Addendum No. 1

RE: Contract # C204739

Graham County (A-0009CB)

NC 143 FROM SR 1223 (BEECH CREEK ROAD) TO 0.5 MILES NORTH OF APPALACHIAN TRAIL.

CLEARING AND GRUBBING  
EROSION CONTROL FOR  
CONSTRUCTION SHEET 34

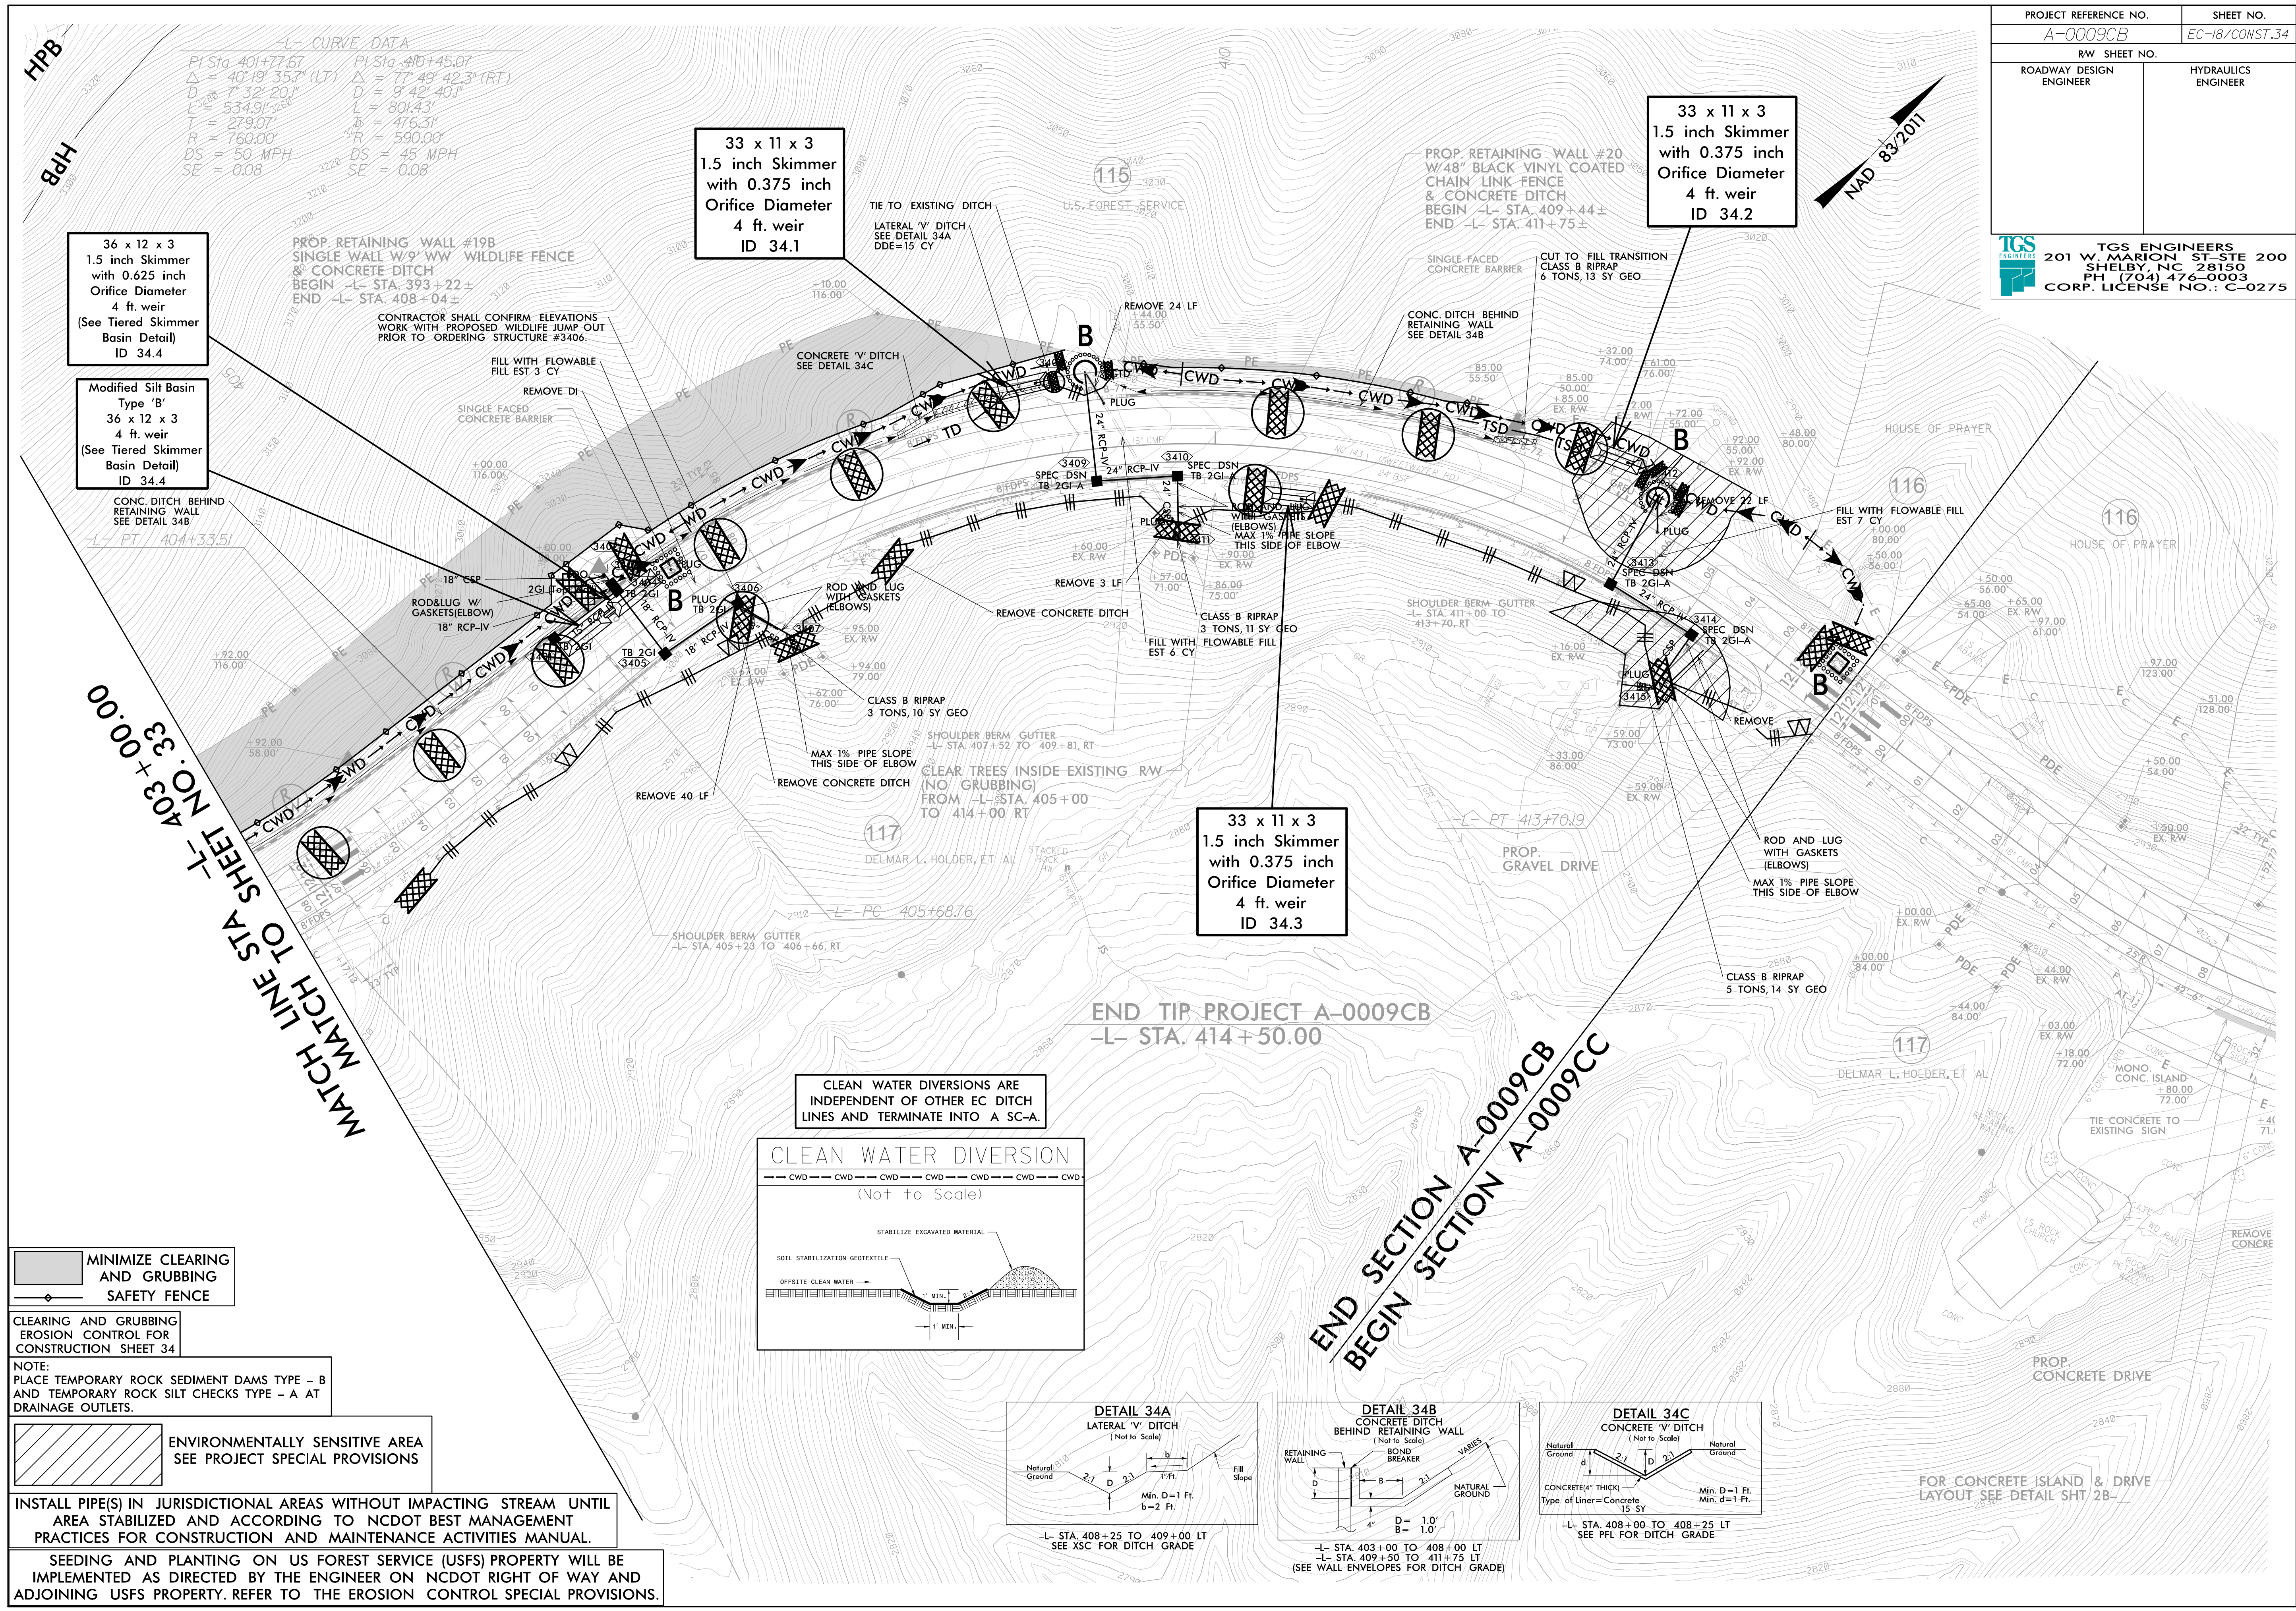
Page No.	Revision
Proposal Cover	Note added that reads "Includes Addendum No. 1 Dated 09-08-2022".
G-51 to G-52	Special Provision NOTES TO CONTRACTOR revised.
EC-5 to EC-6	Special provision for SPECIAL SEEDING AND EROSION CONTROL (DIVISION 14) removed. Special provision for NATIVE SEEDING AND MULCHING removed.
EC-5 to EC-10	Special provision for SEEDING AND PLANTING ON US FOREST SERVICE (USFS) added. Special provision for USFS SEED MIX WITHIN MOWING PATTERN added. USFS SEED MIX BEYOND MOWING PATTERN (NATIVE SEEDING AND MULCHING) added.

USFS Seed Mix within Mowing Pattern

USFS Seed Mix Beyond Mowing Pattern
